# FOREST LAKES FILING NO. 6

A REPLAT OF TRACT B AS PLATTED IN FOREST LAKES FILING NO. 5 RECORDED UNDER RECEPTION NO. 220714540 RECORDS OF EL PASO COUNTY, COLORADO TOGETHER WITH A PORTION OF THE SOUTHWEST QUARTER OF SECTION 28 AND THE SOUTHEAST QUARTER OF SECTION 29, ALL IN TOWNSHIP 11 SOUTH, RANGE 67 WEST OF THE SIXTH PRINCIPAL MERIDIAN, EL PASO COUNTY, COLORADO

# Plat V\_1 redlines.pdf Markup Summary 11-25-2020

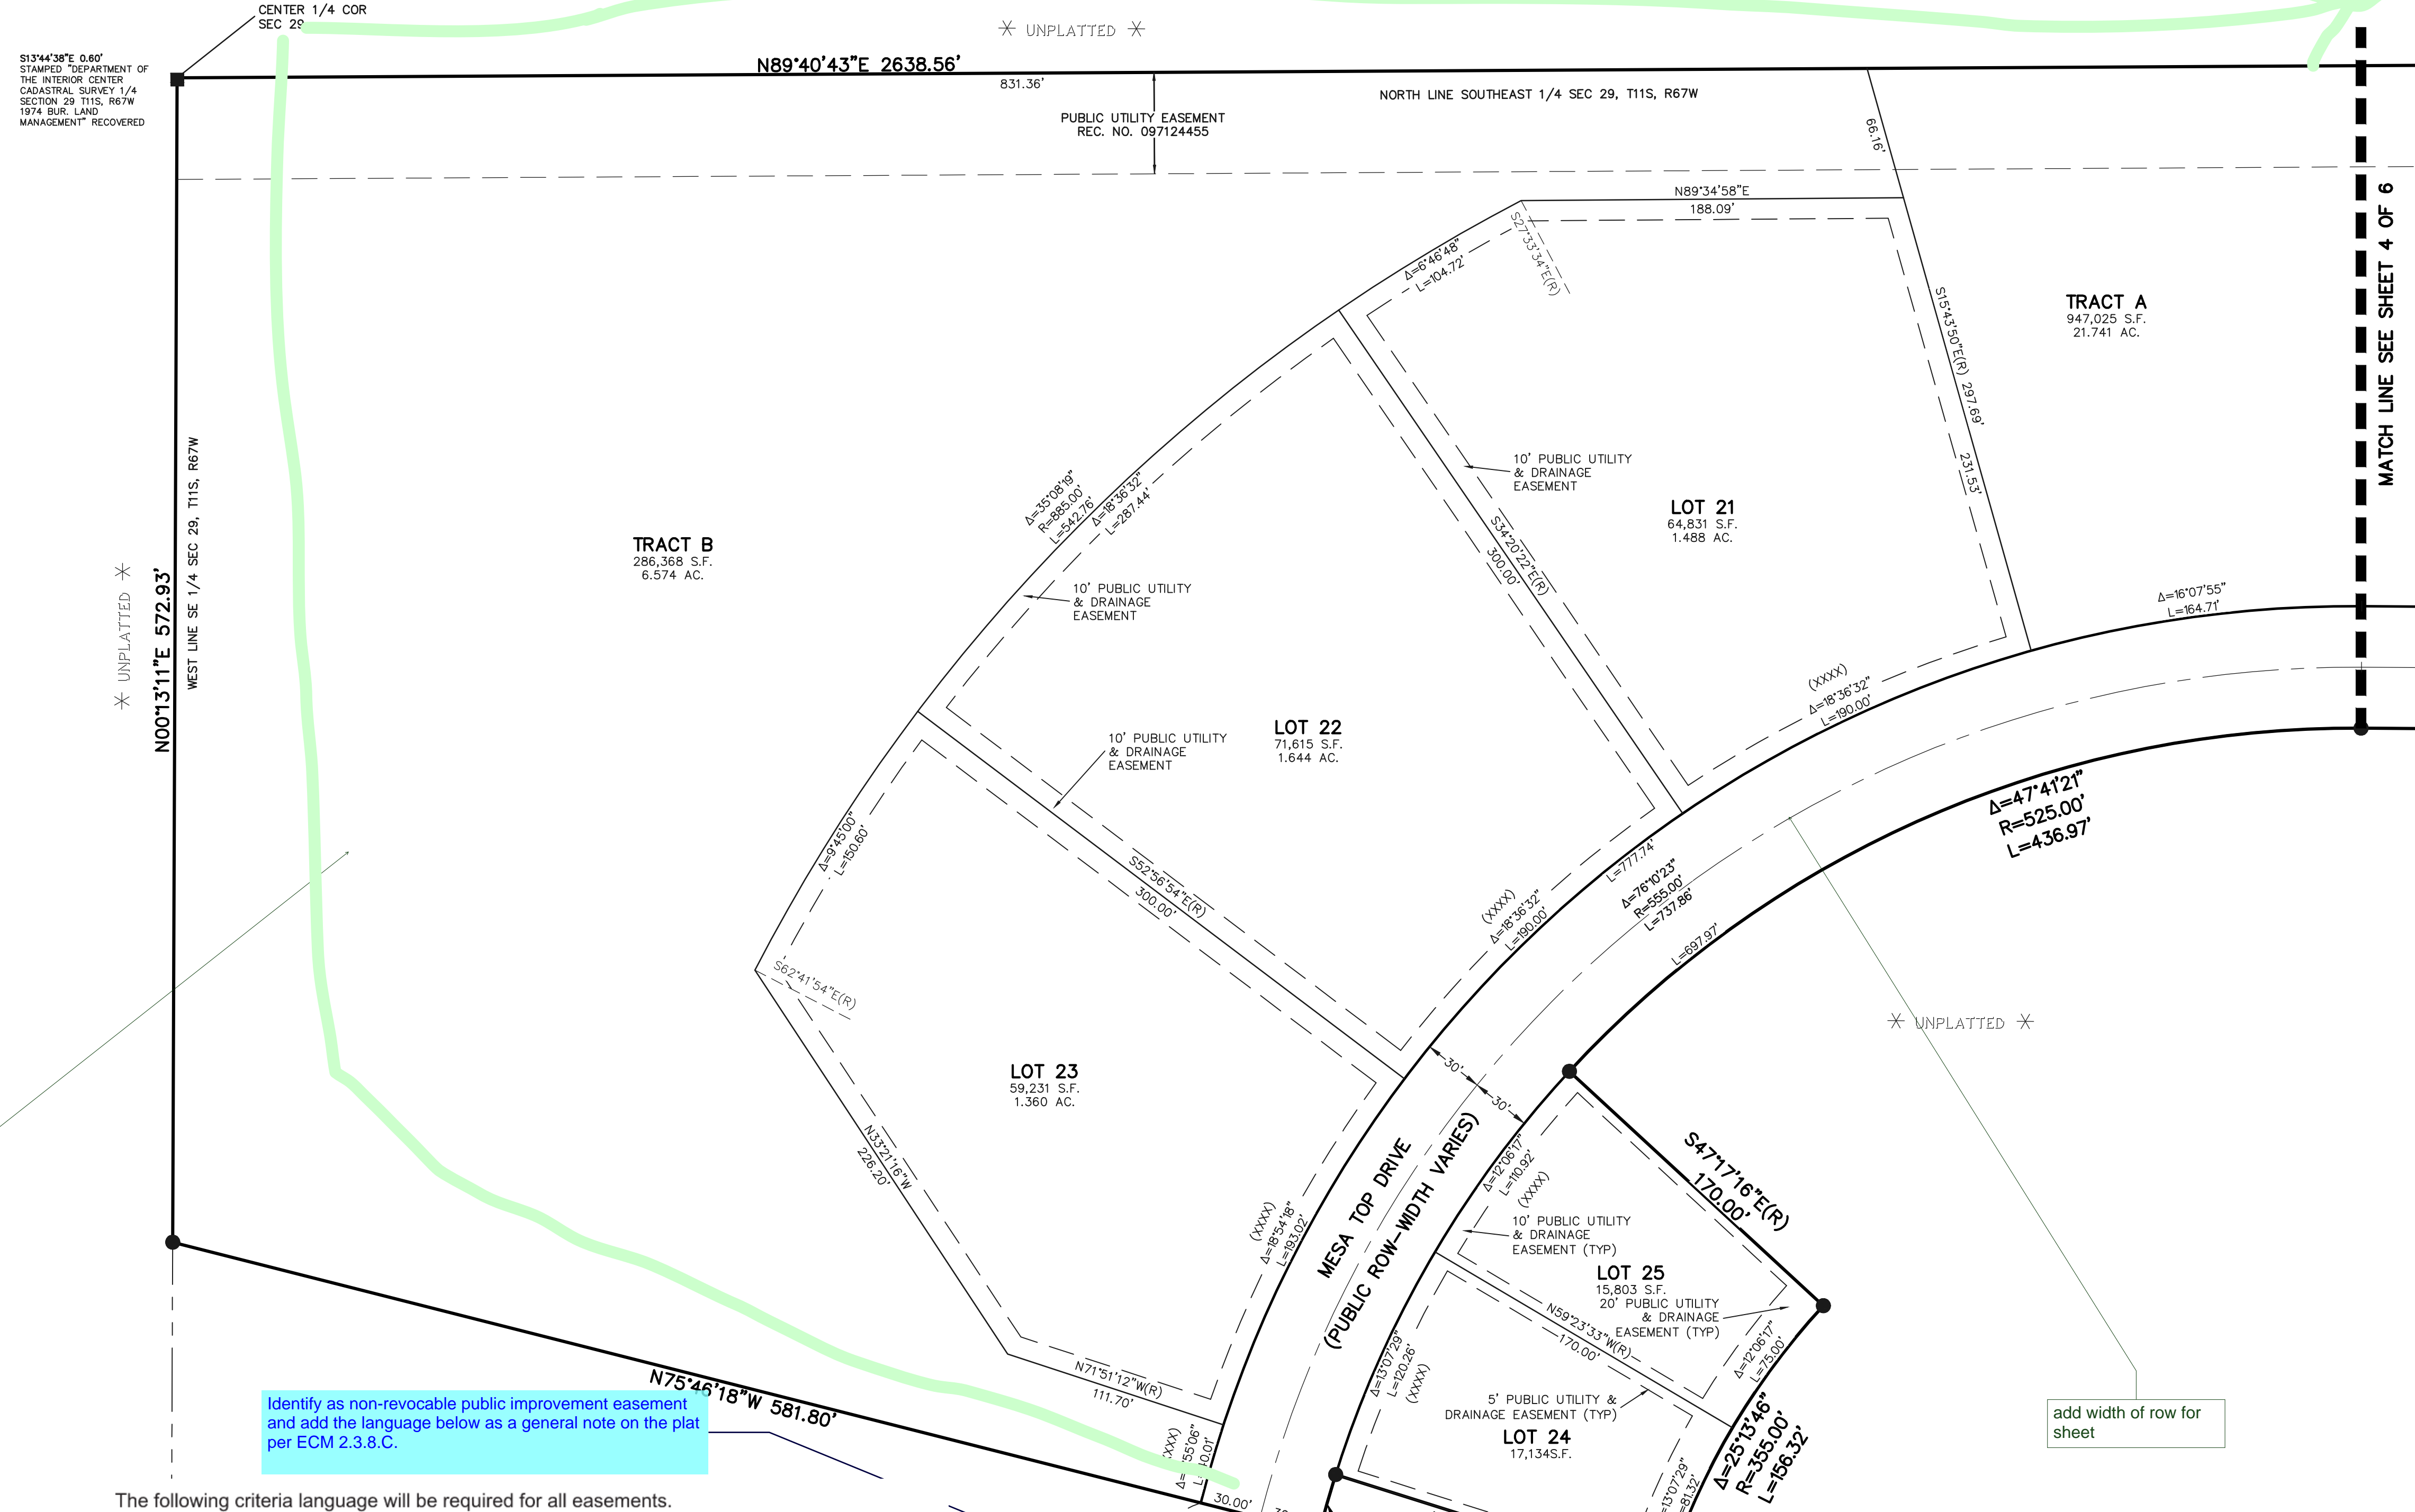
add width of row for sheet

show trails

the trail that goes up to the point was agreed to be removed due to snakes

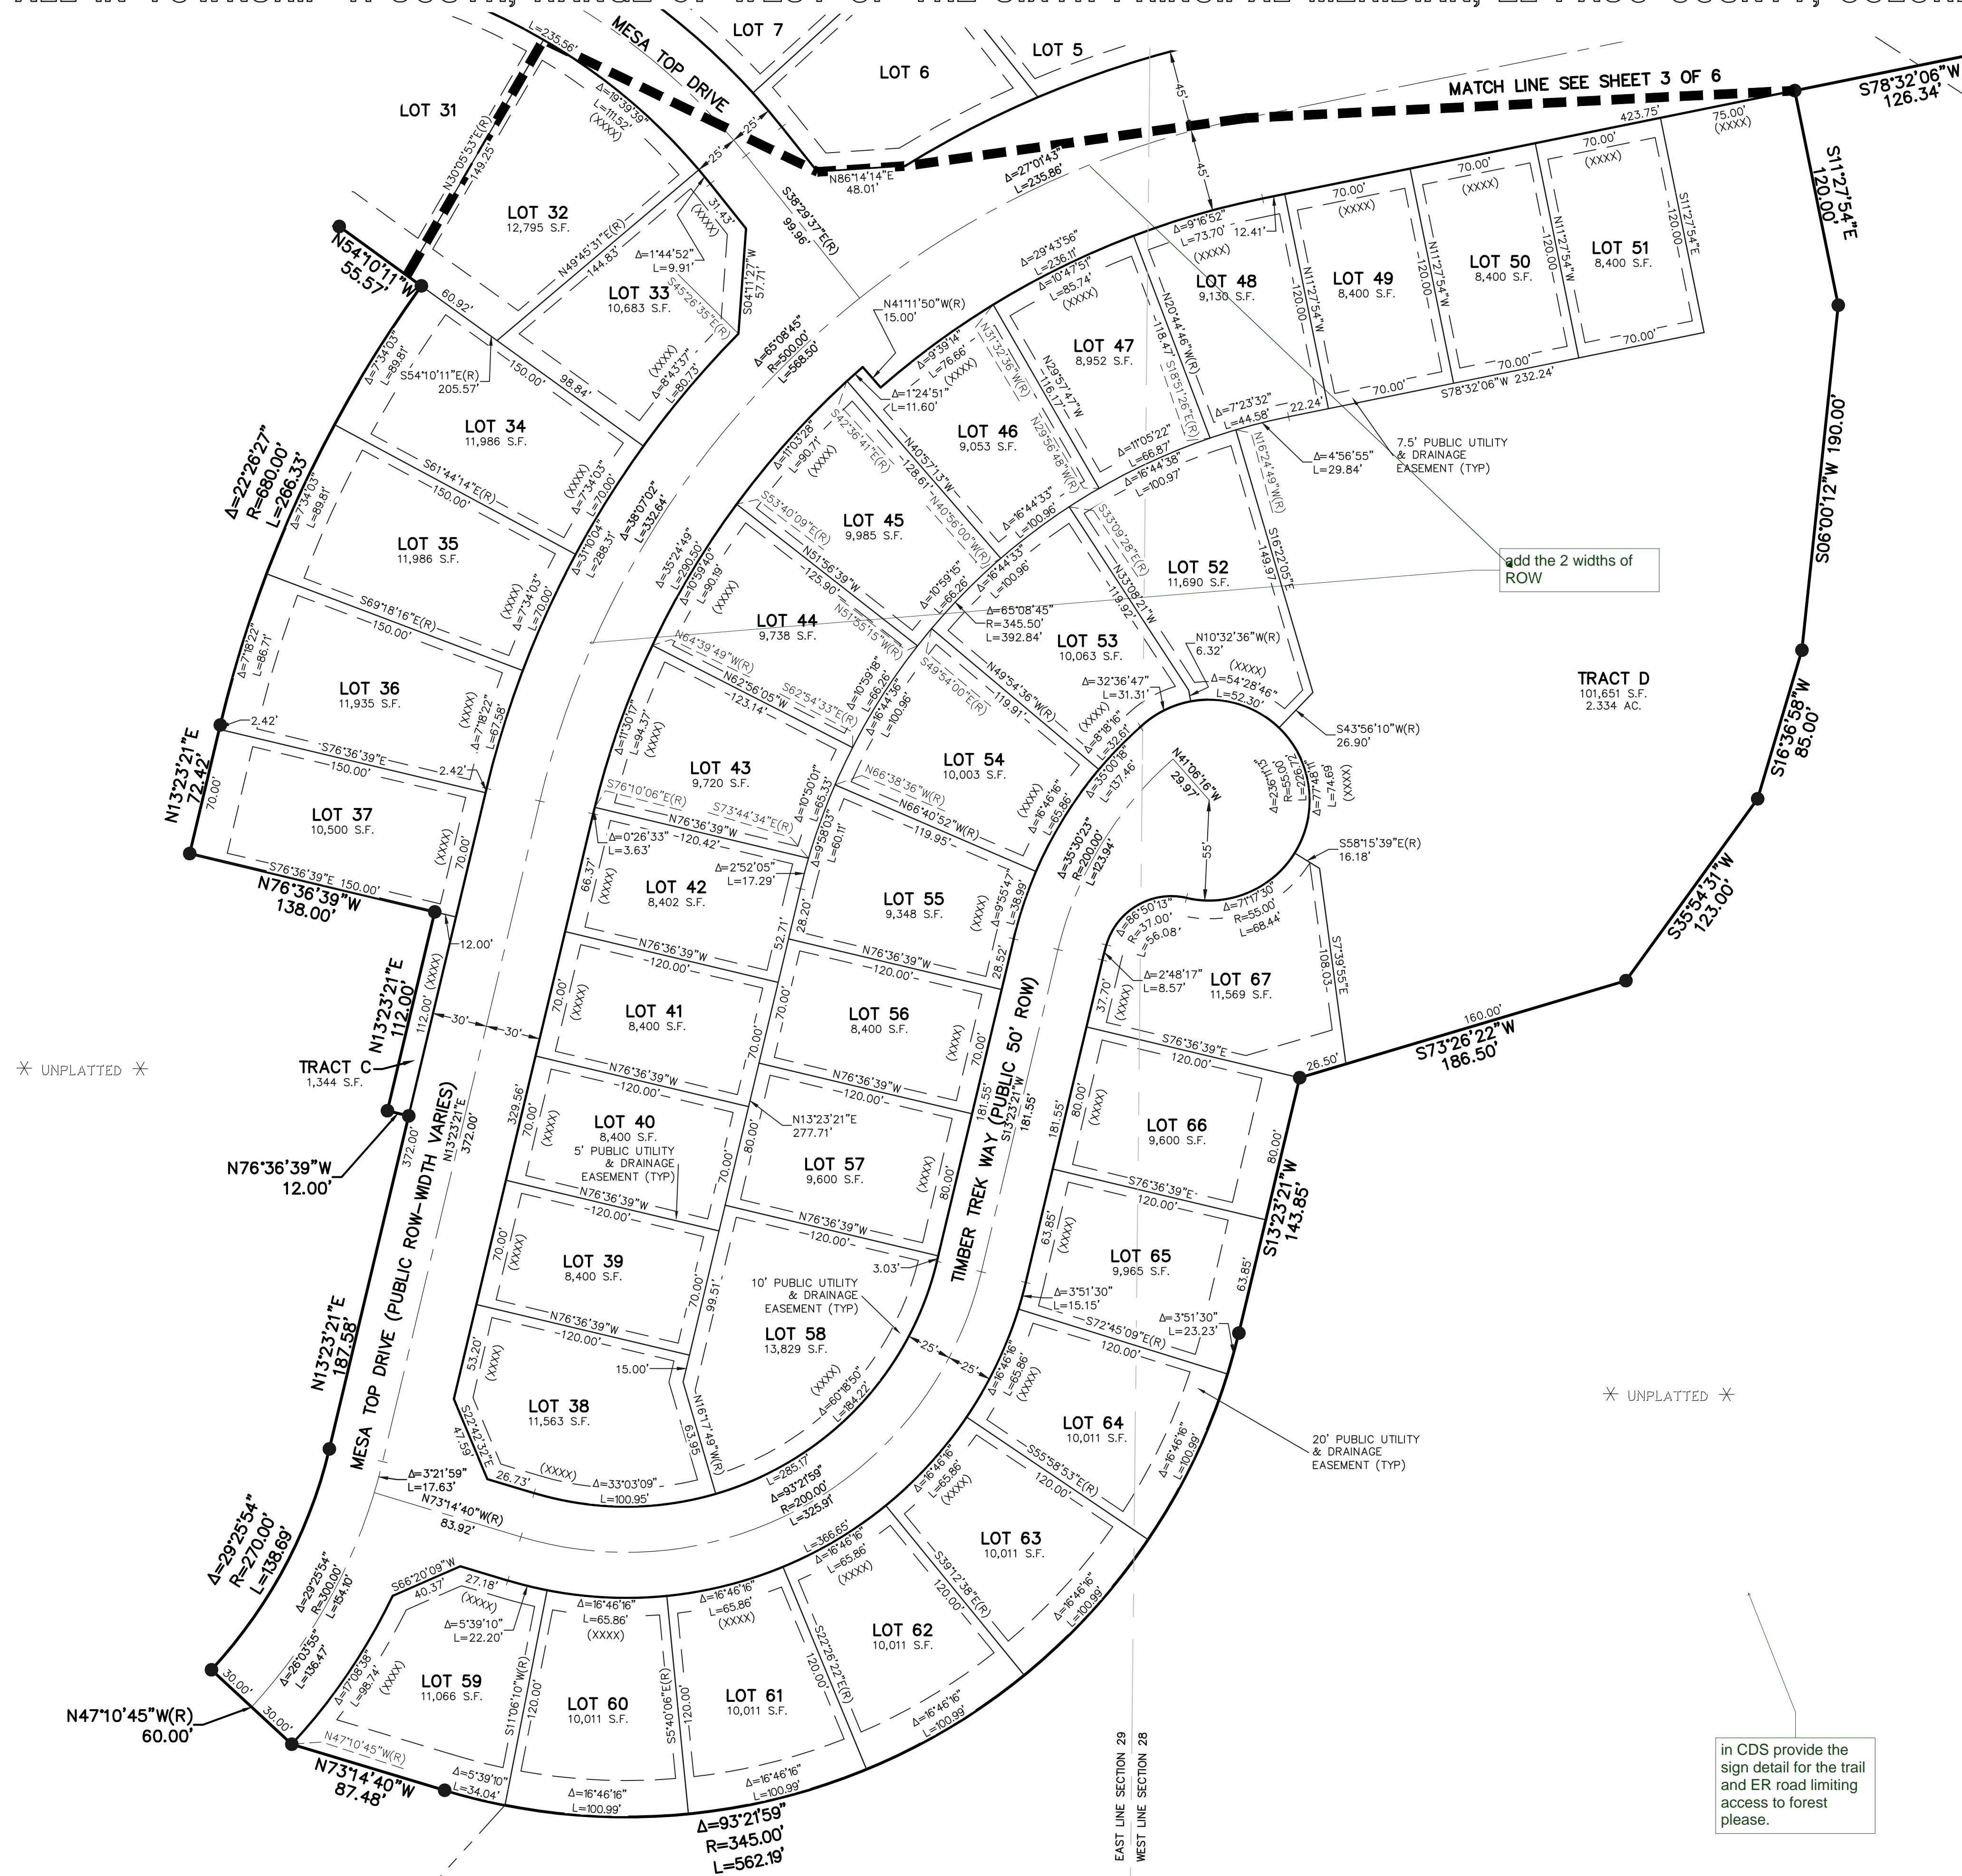
add the 2 widths of ROW

in CDS provide the sign detail for the trail and ER road limiting access to forest please.
